CITY OF PORTLAND, MAINE
ZONING BOARD OF APPEALS

Conditional Use Appeal

DECISION

Location of property under appeal: 1877 Congress Street
Portland, ME 04102

SHEET TITLE	
DETAILED SITE PLAN	
SHEET NUMBER

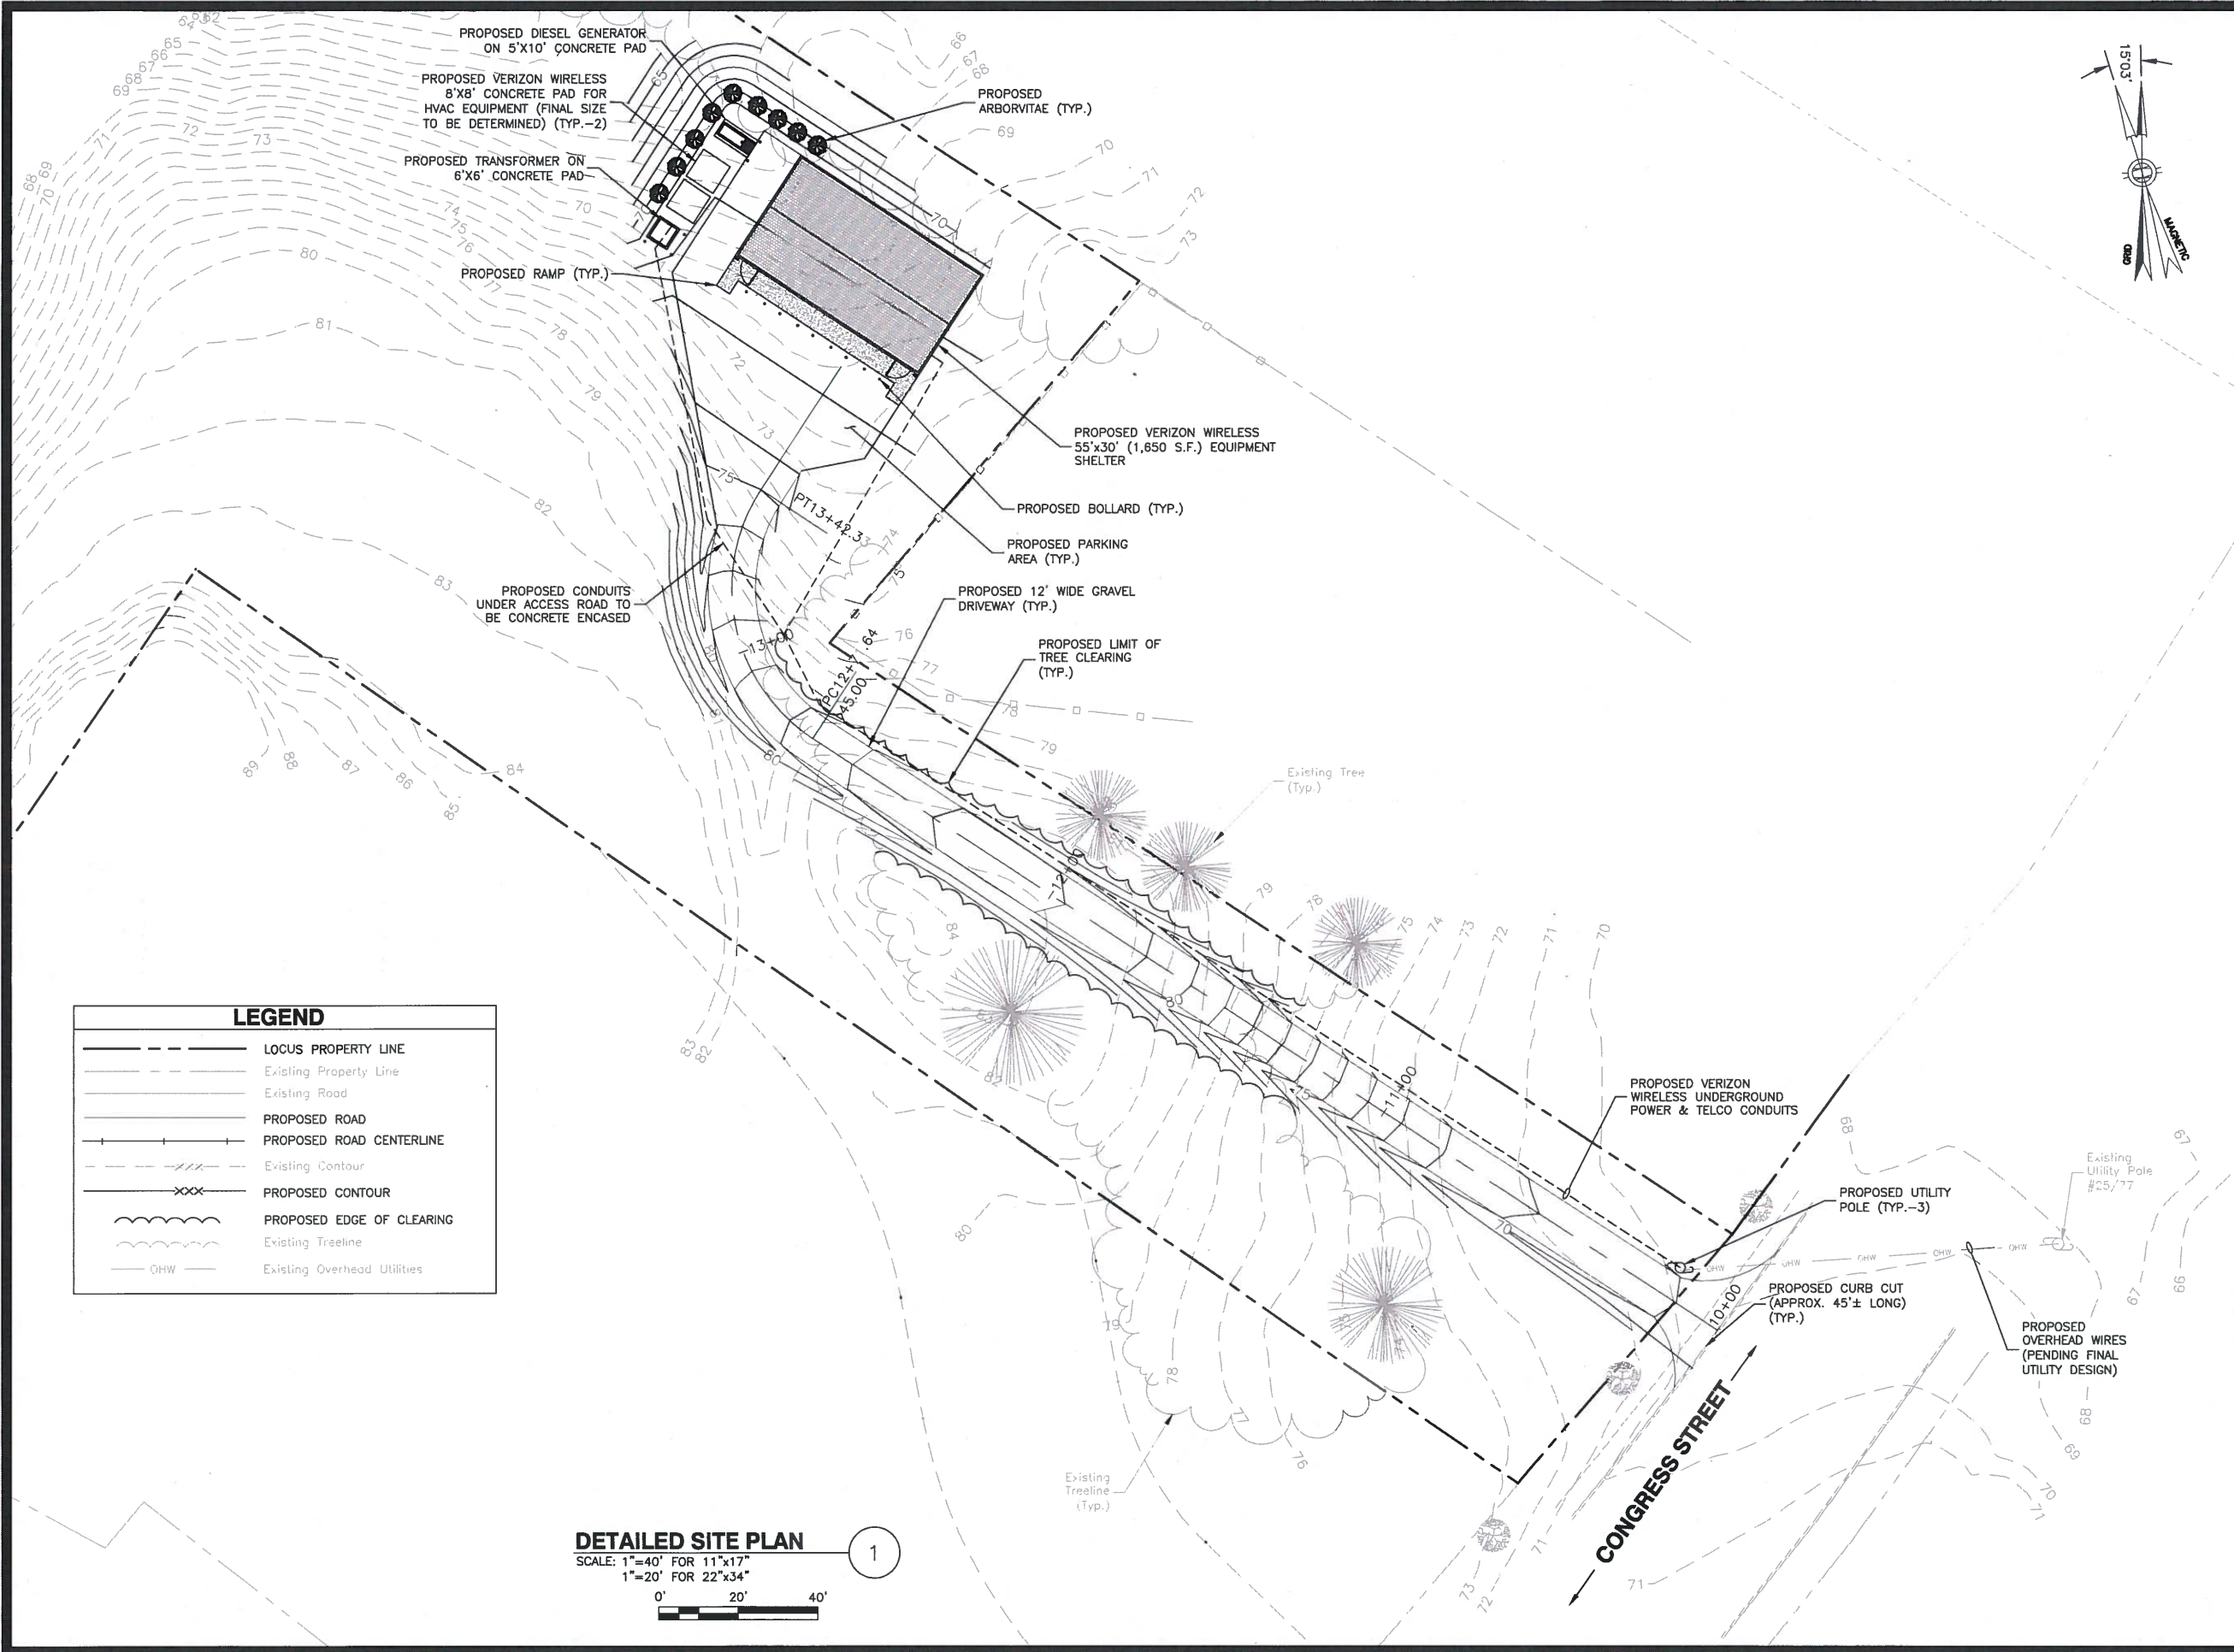
Applicant has submitted new plan-plantings & screenings meant to make the building less intrusive. Fence at least as high as generator. Leave existing trees as identified on the site plan, through Level II site plan arborist would review plantings. ~~elevation~~ height of building couldn't be increased from what is presented in the application.

Fence at least as high as the generator
Leave existing trees as identified on the site
Plan
Level II site plan reviews will occur with
City Arborist & reviewing plantings
Elevation of the building can't be
increased from what is presented in the
application.

move building 18 ft west & drop hill
eliminates need to cut any trees

Z-4

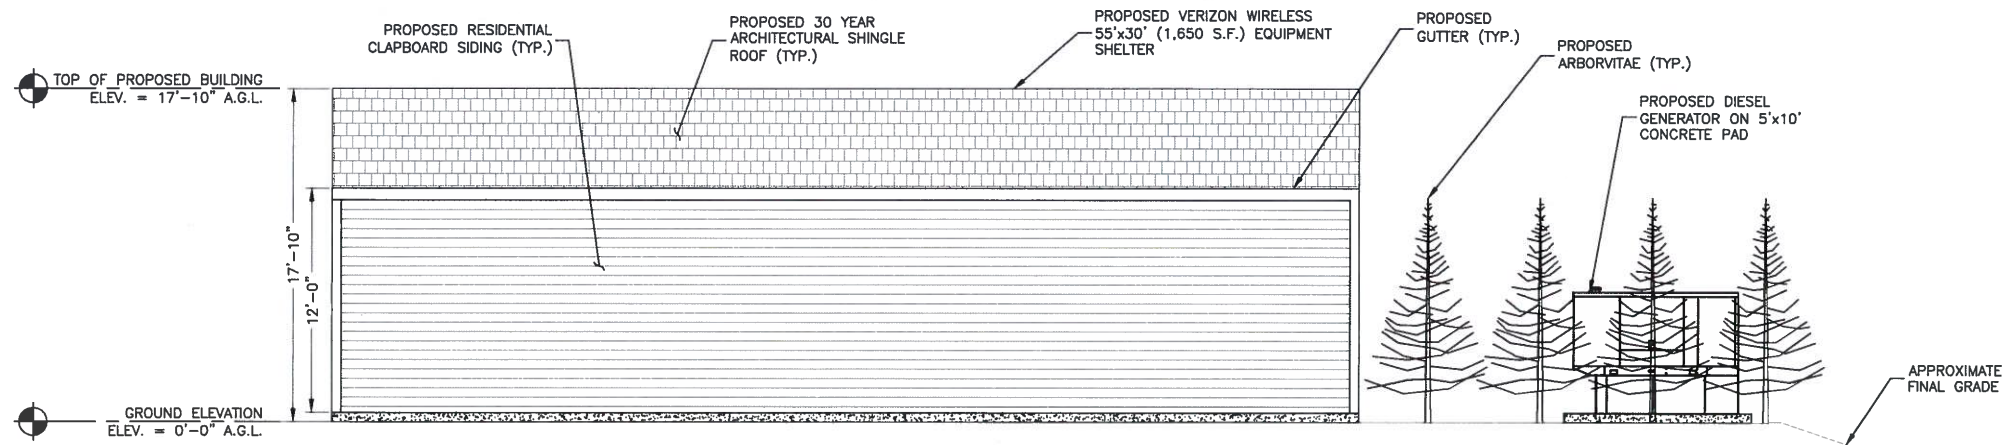
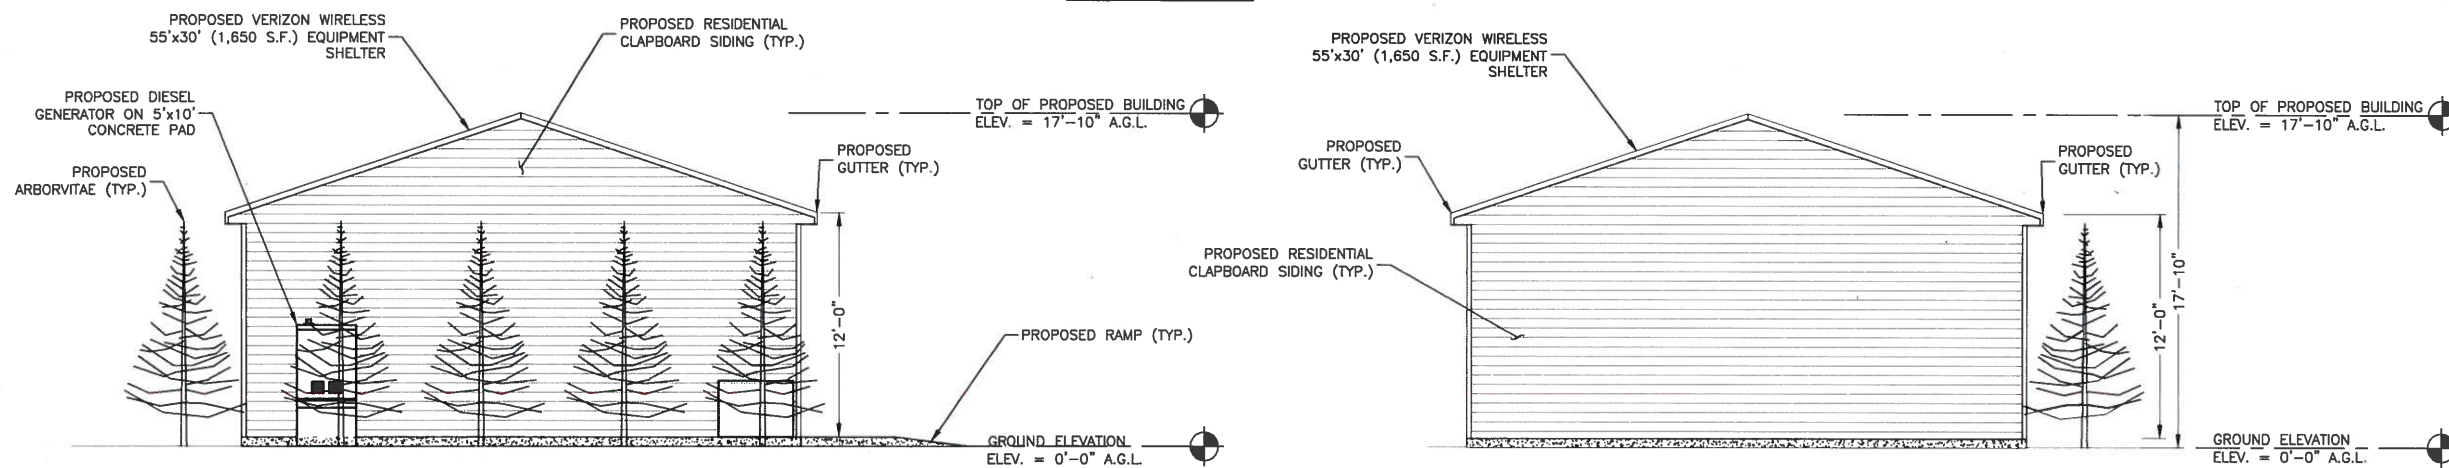
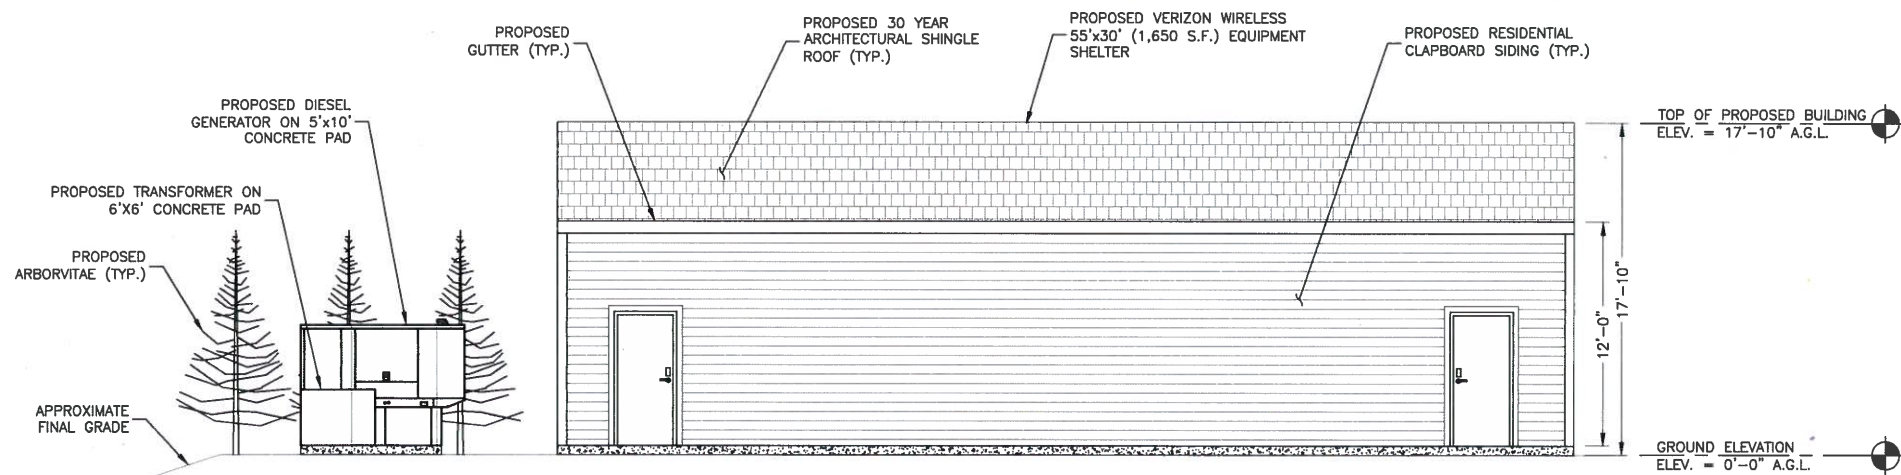
Height of structure is 17 feet. Max height in zone is 35 feet. Design as presented - won't have a greater impact than ~~most~~ other ^{allowable} ~~allowable~~ uses in zone. ~~For~~ University, art school & places of assembly are allowed and this use has no greater impact. Dissent indicates this is a Commercial use and Conclusion: (check one) will have a substantial impact on residential zone, including reducing property values.

Same or lower height as original
application - further away from property lines
